CITY OF ALBUQUERQUE

April 7, 2017

Phil Lindborg, Boyhan LLC: phillindborg@comcast.net
Alameda and Louisiana Commercial Development

Re: Drainage Ordinance (14-5-2-1) Violation for Erosion and Sediment Control

Legend	
---	Erosion Sediment Control Plan
---	Staging Area
---	Stabilized Construction Entrance
---	Silt Fence
---	Block Wall
●	Chemical Toilet
Ⓢ	Posting Sign

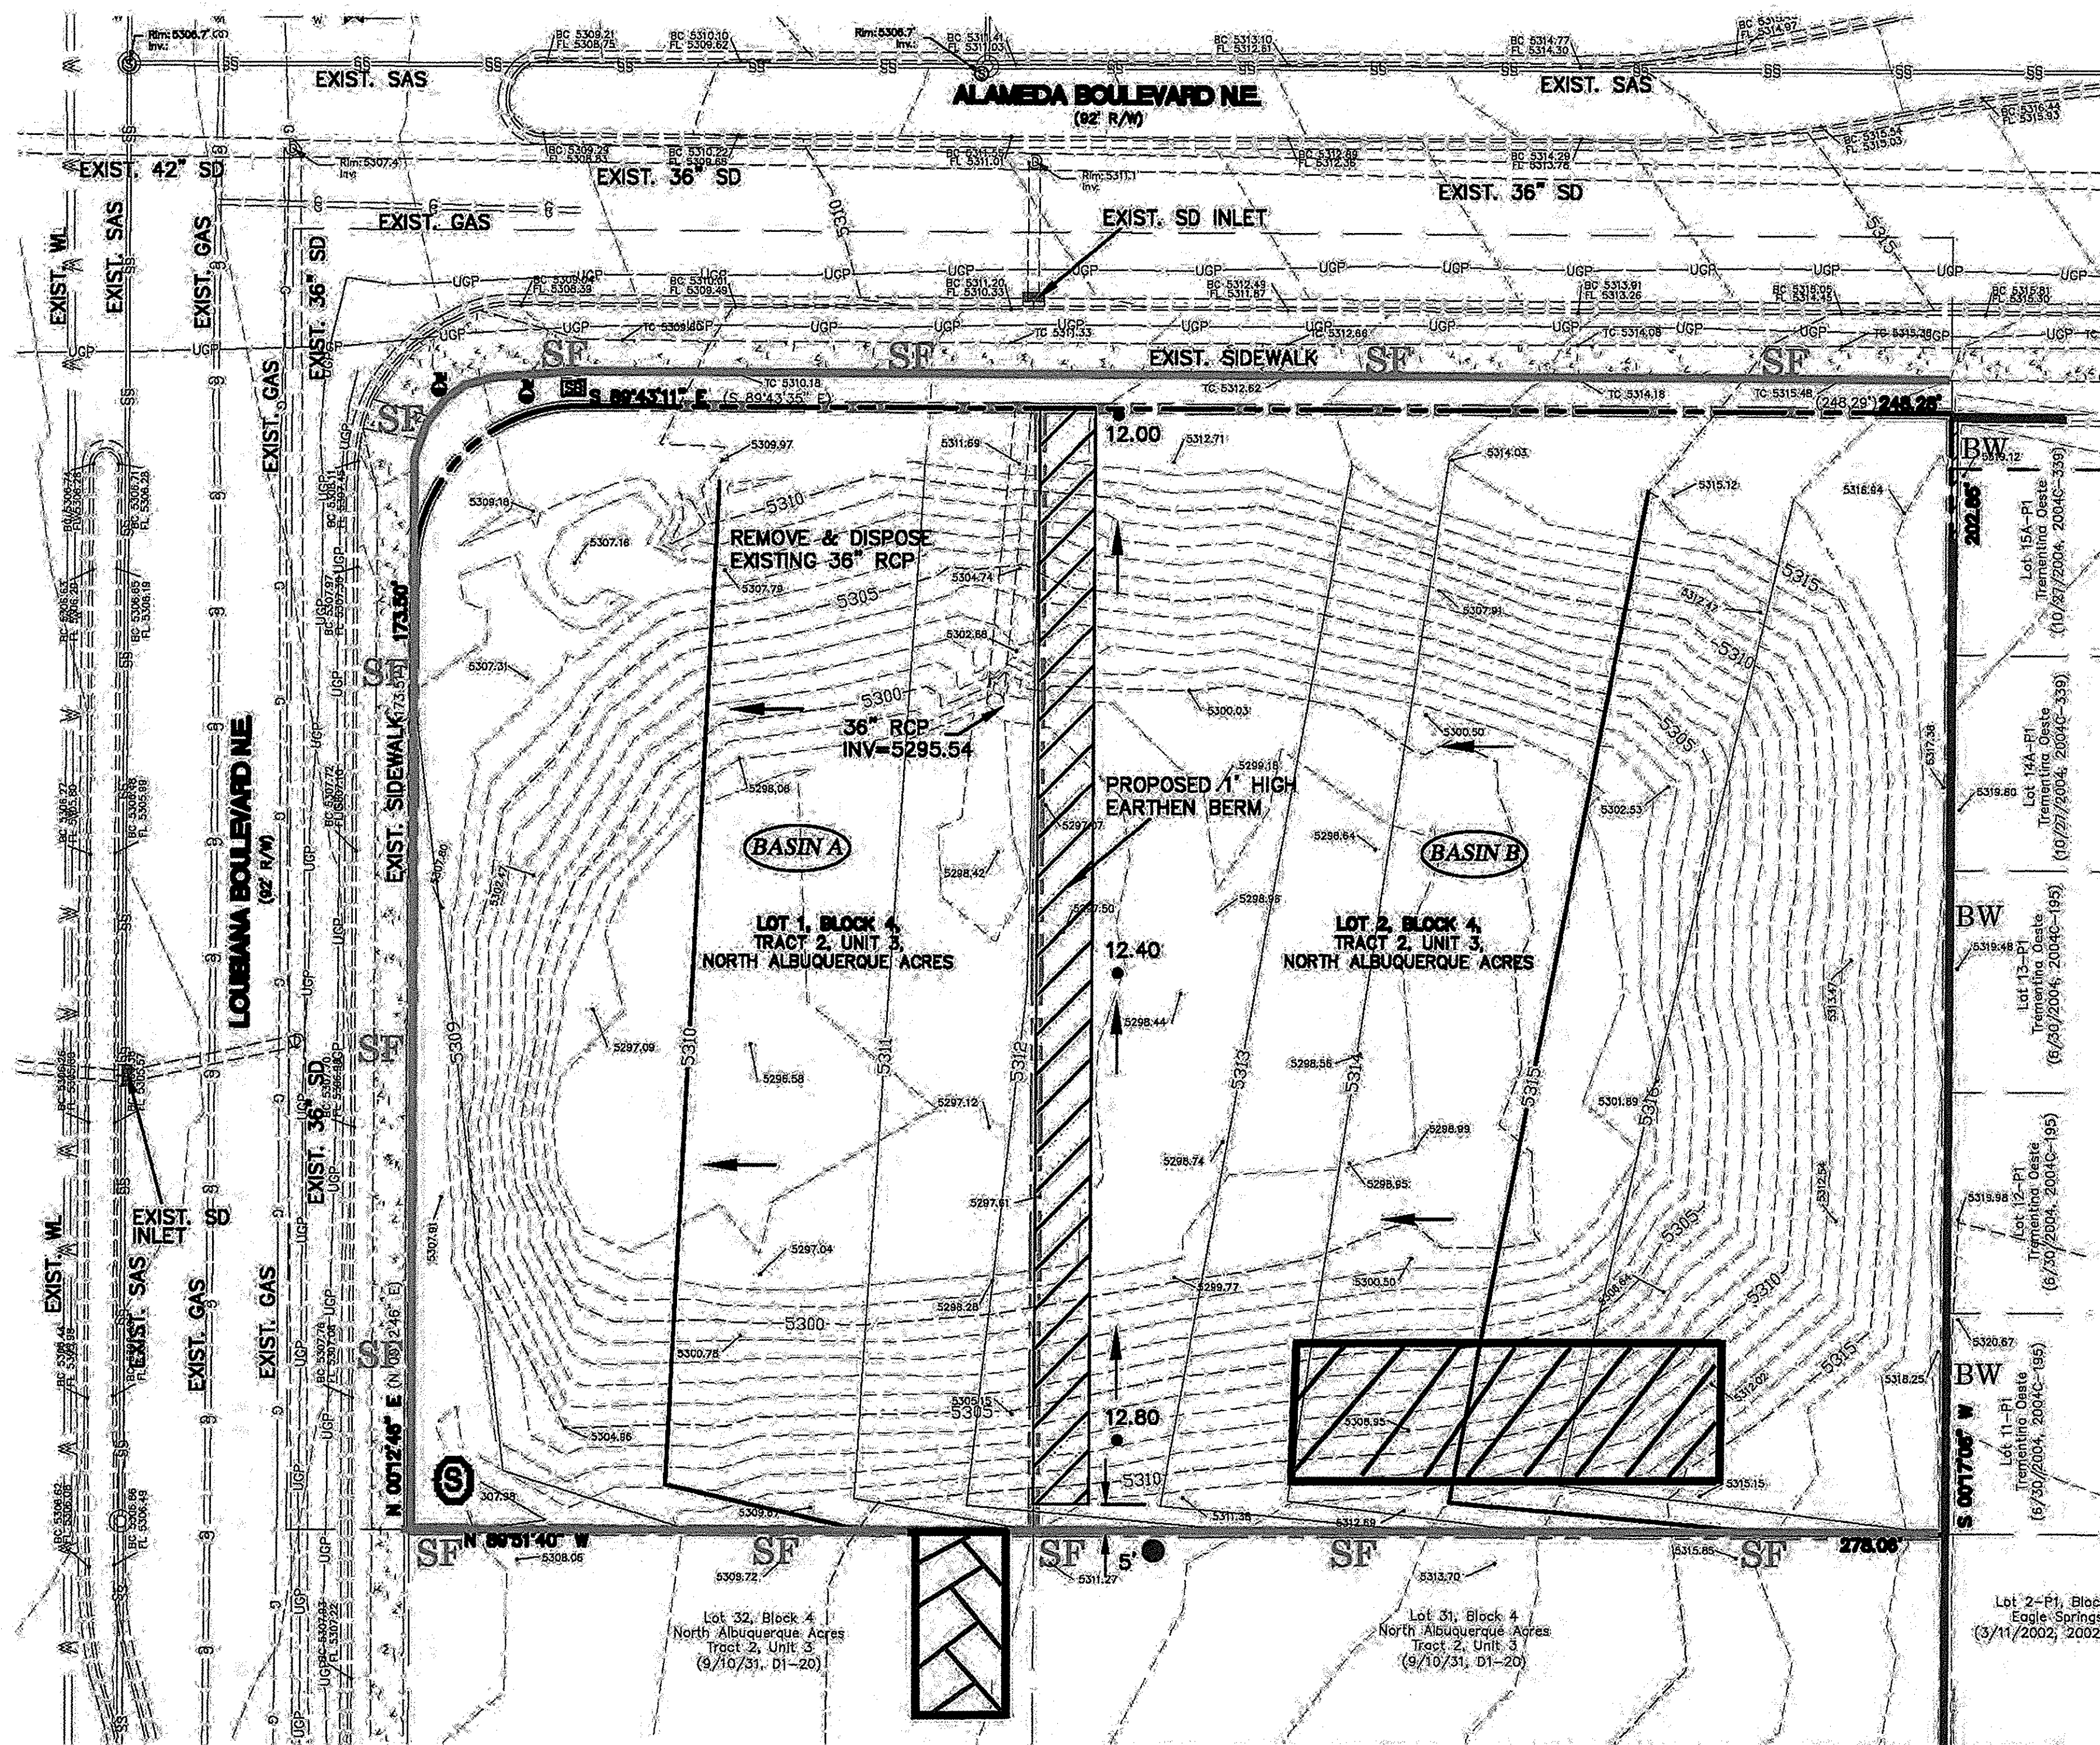
1. Major track-out onto Signal Avenue, Louisiana Blvd and Alameda Blvds.
2. There was no track-out pad and vehicles were leaving through the lot to the south. The approved Erosion and Sediment Control Plan shows the track-out pad on Louisiana.
3. Gap in the silt fence at the northeast corner.

1. Remove sediment from street and gutter pan on Signal Ave, Louisiana Blvd and Alameda Blvd from Louisiana to Via de Paz St.
2. Install the track-out pad per approved ESC plan.
3. Replace silt fence in Northeast corner.
